**From:** Cherne, Curtis  
**Sent:** Thursday, January 12, 2017 12:42 PM  
**To:** Jeff Wooten (jeffwooten.pe@gmail.com)  
**Cc:** Al-Najjar, Marwa G.; Biazar, Shahab  
**Subject:** comments/suggestions on Wendy's 4900 Central

| PROJECT TITLE<br><b>WENDY'S RESTAURANT</b><br>4900 CENTRAL AVE SE<br>ALBUQUERQUE, NEW MEXICO 87108 |        | JOB NO.<br>2016043                 |  | DRAWN BY:<br>JEFF WOOTEN |  |
| PROJECT MANAGER<br>JEFF WOOTEN   |        | SHEET TITLE<br><b>Grading Plan</b> |  |                          |  |

PROJECT TITLE WENDY'S RESTAURANT 4900 CENTRAL AVE SE ALBUQUERQUE, NEW MEXICO 87108	DRAWN BY: JEFF WOOTEN	JOB NO. 2016043	SHEET TITLE Grading Plan
DATE 2/3/17	SCALE AS NOTED	SHEET NO. C1.1	OF 1

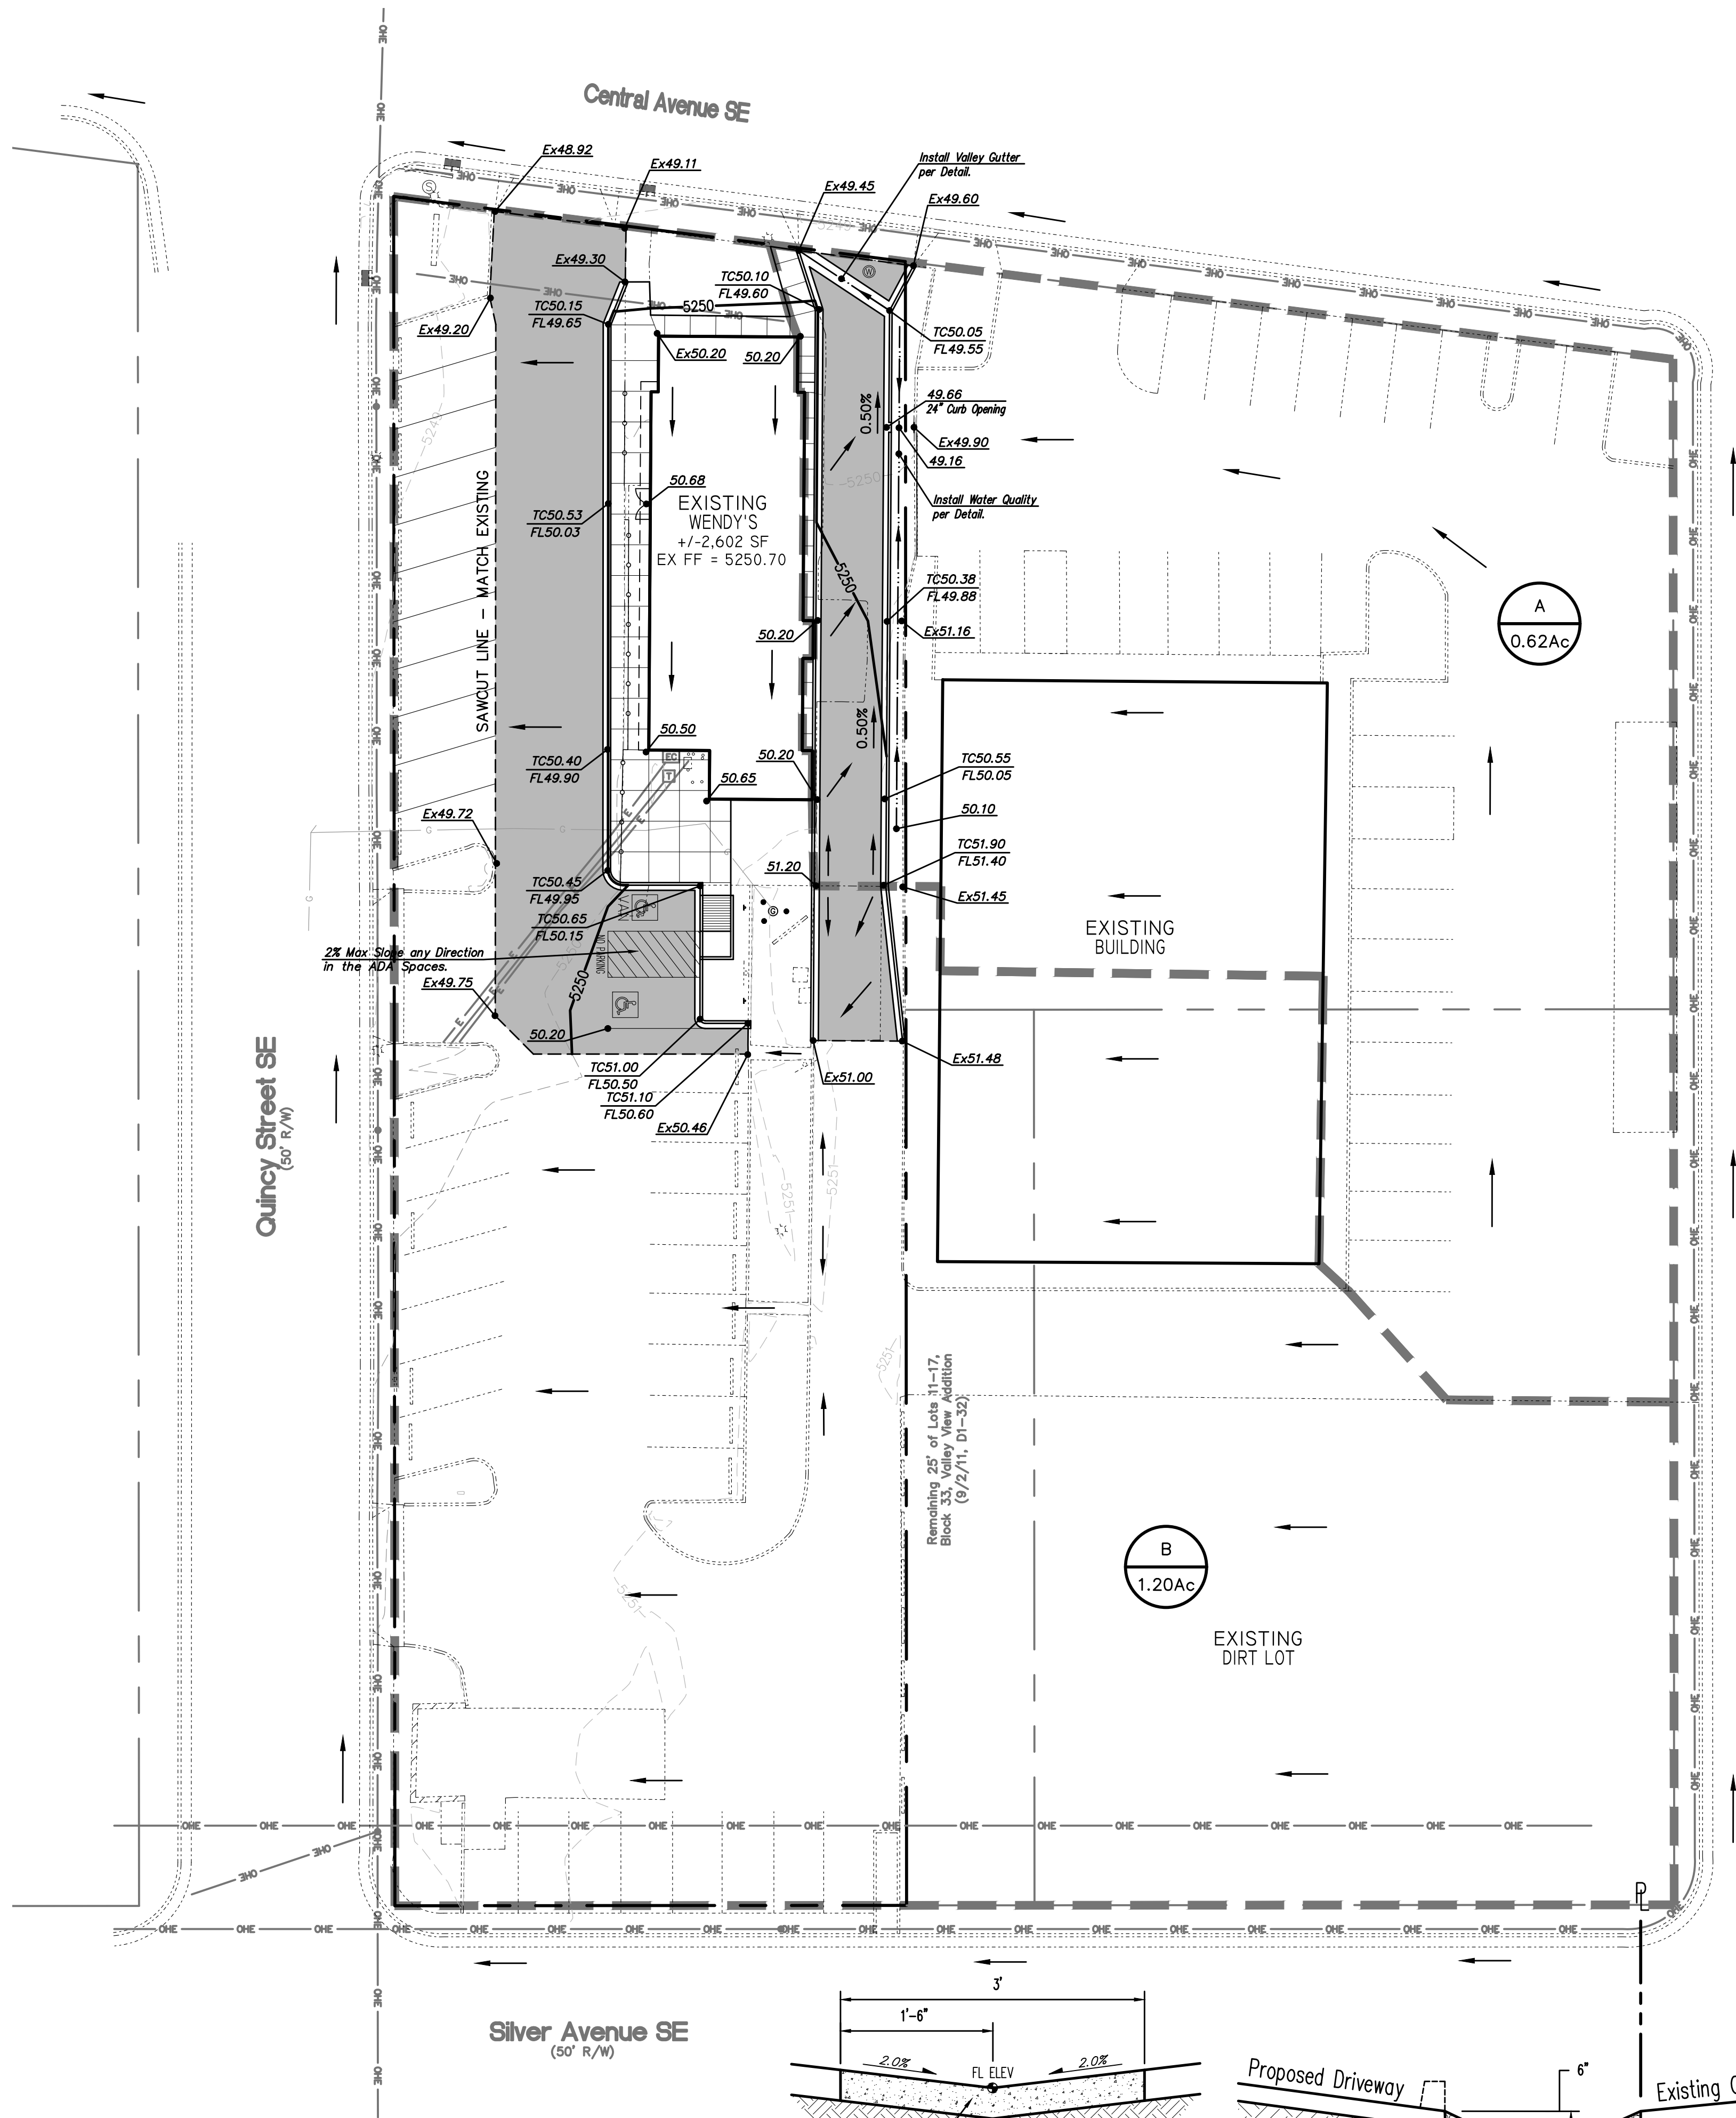
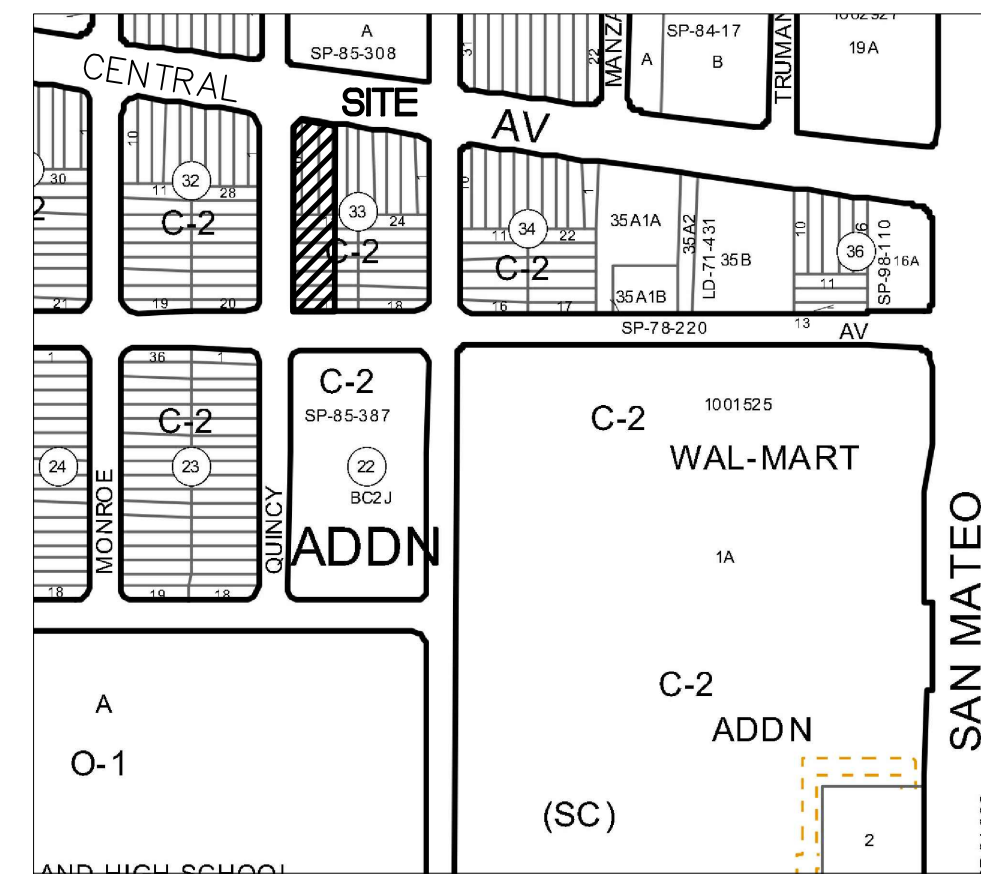
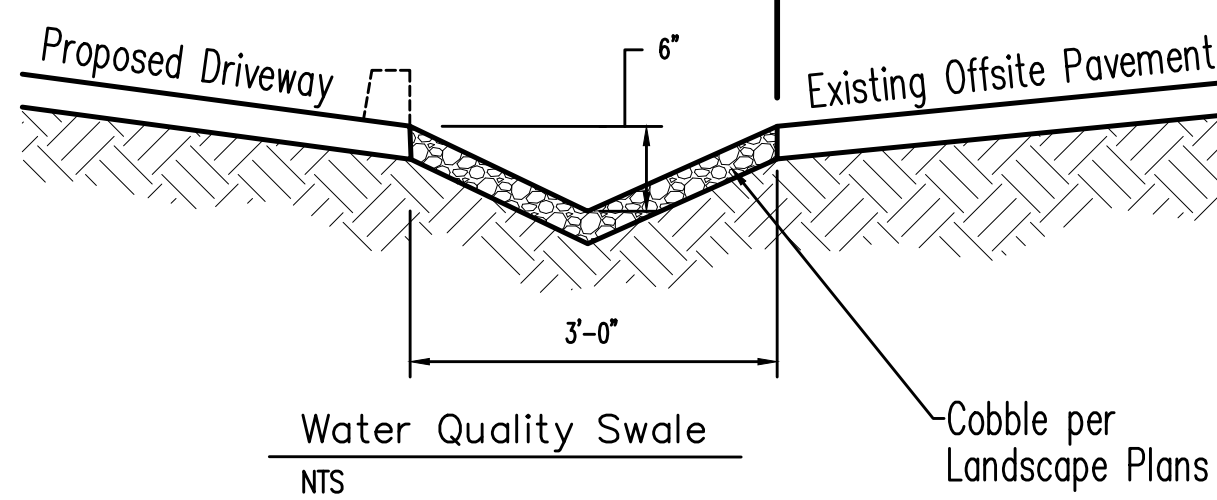
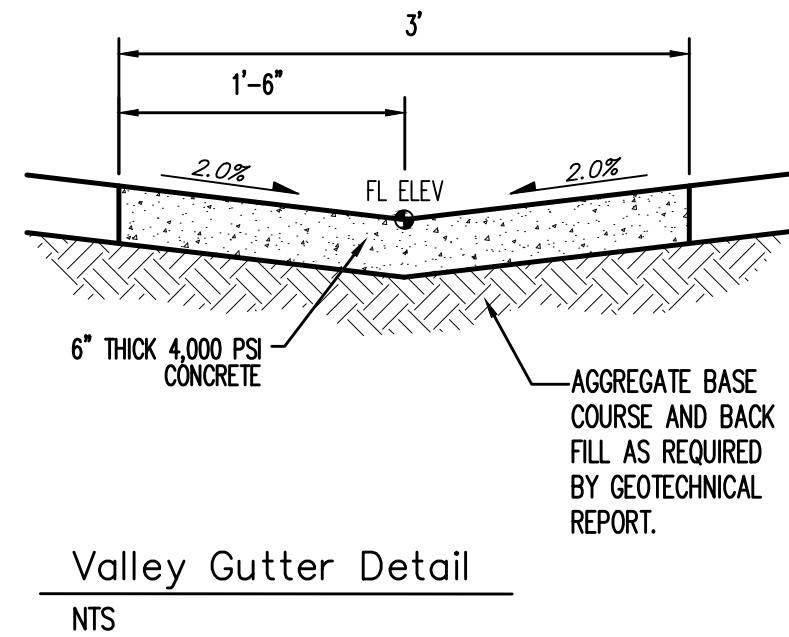
1. Include a narrative. All plans require a narrative.
2. There are offsite flows that drain through an existing curb cut. Either quantify or say something about how the existing curb cut works and should continue to work in the future.

3. Proposed conditions Q and Volume. I don't think you need to provide calcs, but you should mention that proposed flows and volumes will be slightly lower than existing flows and volumes due to the landscaping.

4. It appears to be relatively painless to have flows along the eastern edge drain into the proposed landscape area. Provide curb opening at FL 49.88 and flows could leave the landscaping just upstream of the proposed channel. Section of landscape area could look like landscape buffer swale (5:1 side slopes).

5. It appears that construction of the new channel is partially on the lot to the east. Provide written (email OK) approval from the property owner or authorized agent (e.g. General Manager).
